Fire Marshal Division

RE: McDonald's Restaurant
935 NC Hwy 24-87

Application Number FMFW1808-0009

Table with 2 columns: SHEET NO., T1.0, APPENDIX B

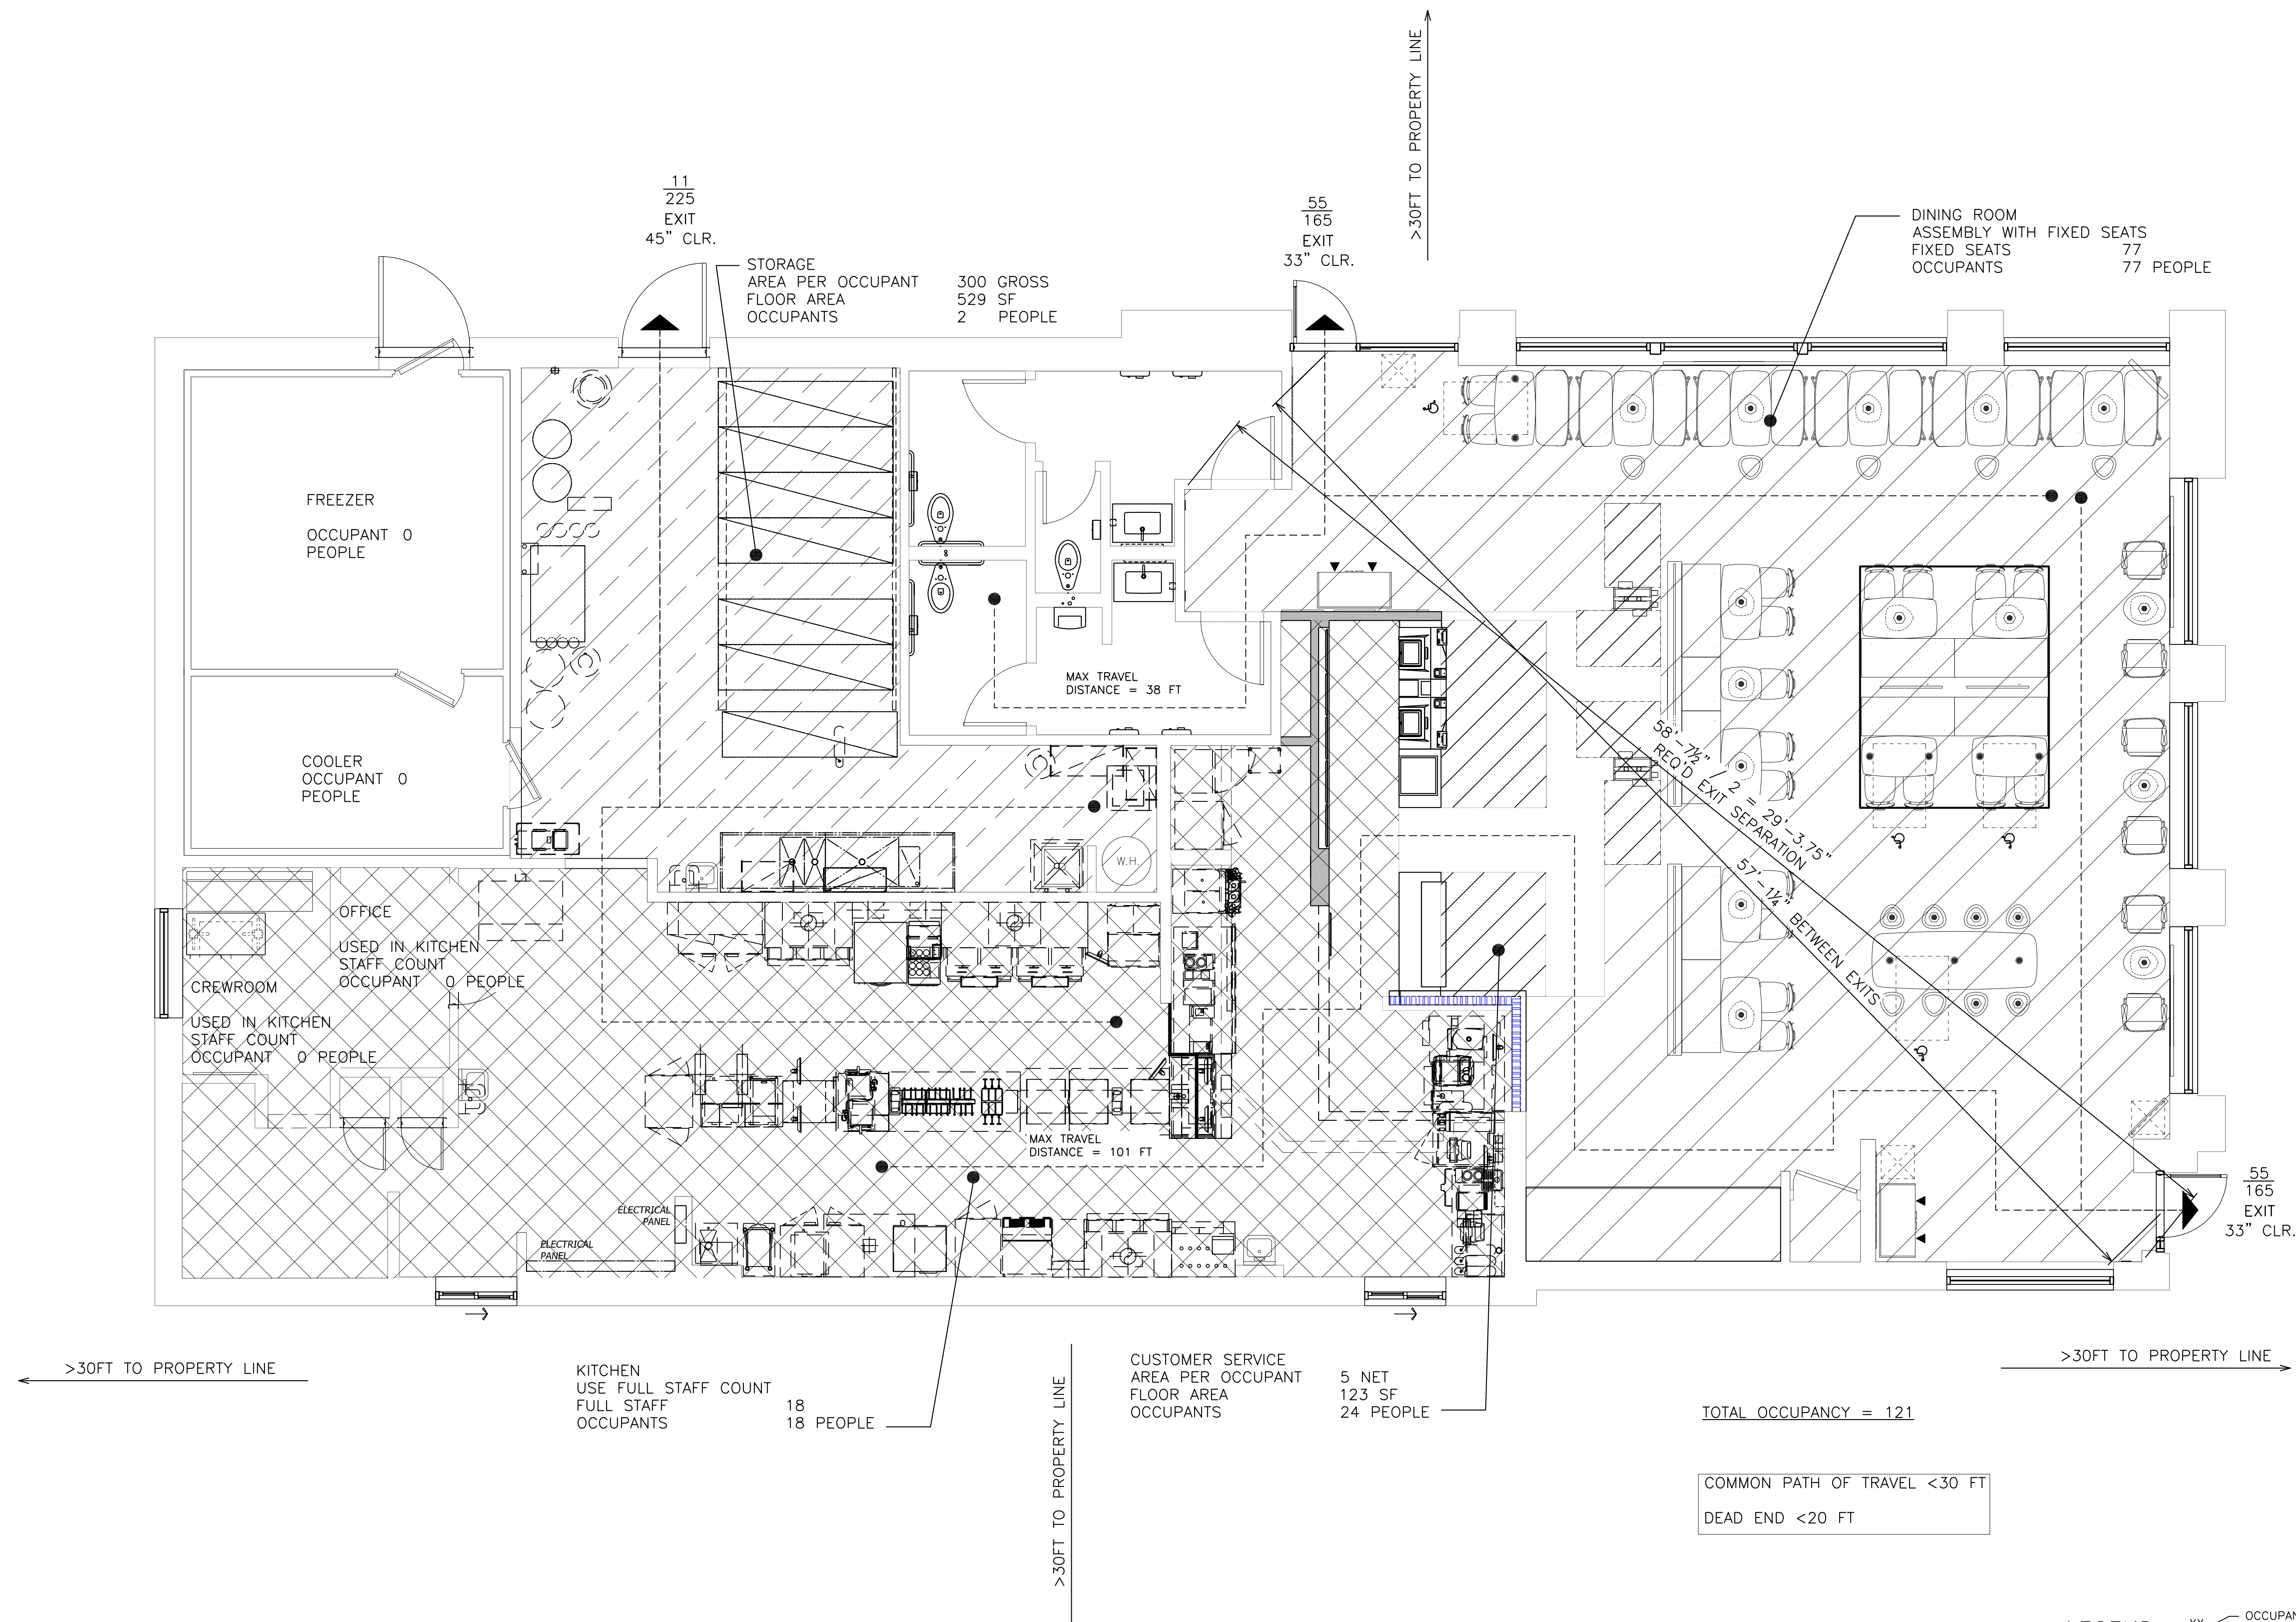
- **Panic Hardware**
 - UL 305 listed panic hardware is required on exit doors serving a room/space with an occupant load >50, also indicated on Building code summary. Panic hardware is not included on door schedule sheet B8 of Drawings.
